TOWN AND COUNTRY PLANNING ACT 1990 FULL

Reference: H21-1138-25 **Date of Decision:** 16th January 2026
Applicant: Mr N Dack
13 St Mary'S Gardens
Long Sutton
Spalding
Lincolnshire
PE12 9DU
Location: Lowgate Farm Lowgate Tydd St Mary Spalding
Description: Proposed conversion of two brick-built barn buildings to form a single family dwelling (barn A) and associated garage (barn B)

South Holland District Council, in pursuance of the provisions of the Town and Country Planning Act 1990 (as amended), hereby give notice that permission has been REFUSED (or equivalent) for the development referred to above, for the following reason(s):

Drawing Title:
Proposed Floor plan & Elevations

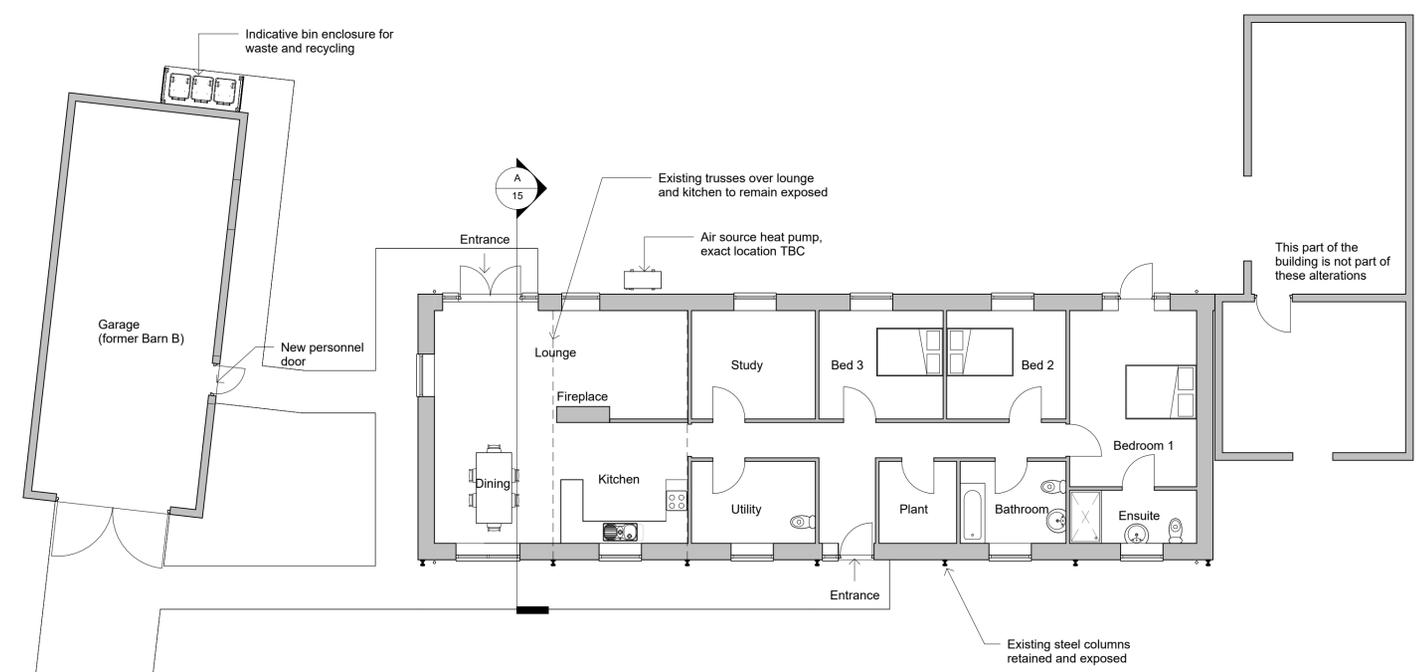
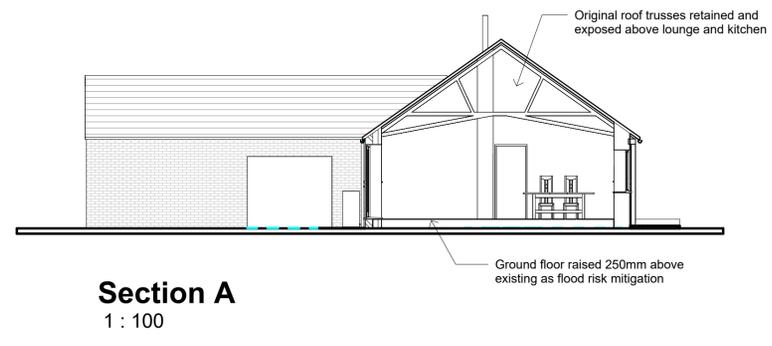
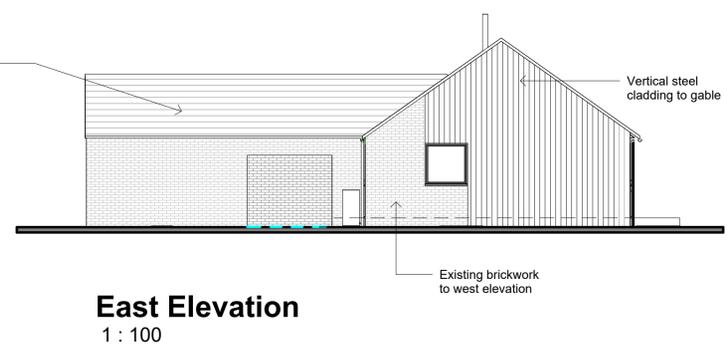
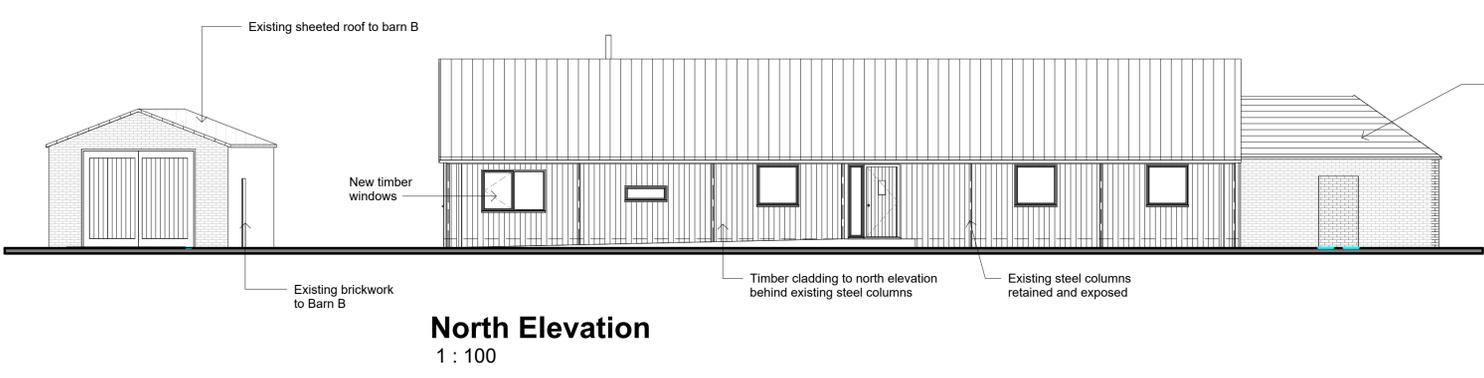
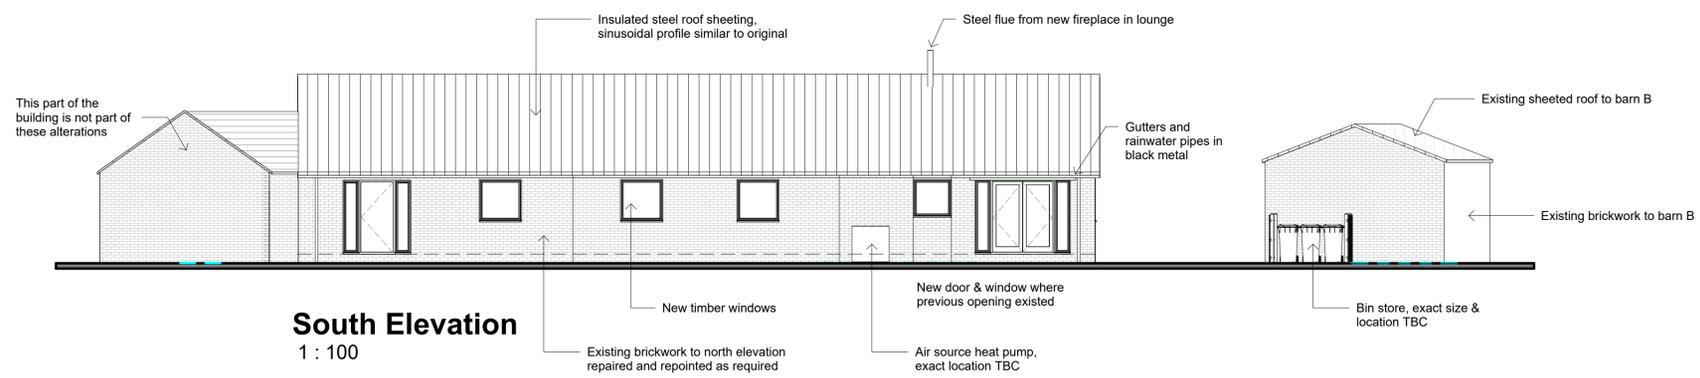
- 1 Policy 23 of the South East Lincolnshire Local Plan (2019) is concerned with proposals for the conversion of existing buildings, which are located outside defined settlement boundaries, to residential use that will be permitted provided that they meet a set of five criteria. This proposal is considered to be in conflict with criteria 1 of Policy 23 due to the extent of works required to facilitate the conversion.

As an open fronted barn, the conversion would necessitate the creation of an entirely new elevation in order to be habitable, in addition to the reconstruction of an existing elevation. This is considered to be an overly substantial alteration, in excess of the limitation of Policy 23 of the South East Lincolnshire Local Plan, 2019 which requires buildings to be structurally sound and capable of conversion without the need for significant extension, alteration or rebuilding.

The proposal would therefore be contrary to Policies 1 and 23 of the South East Lincolnshire Local Plan, 2019.
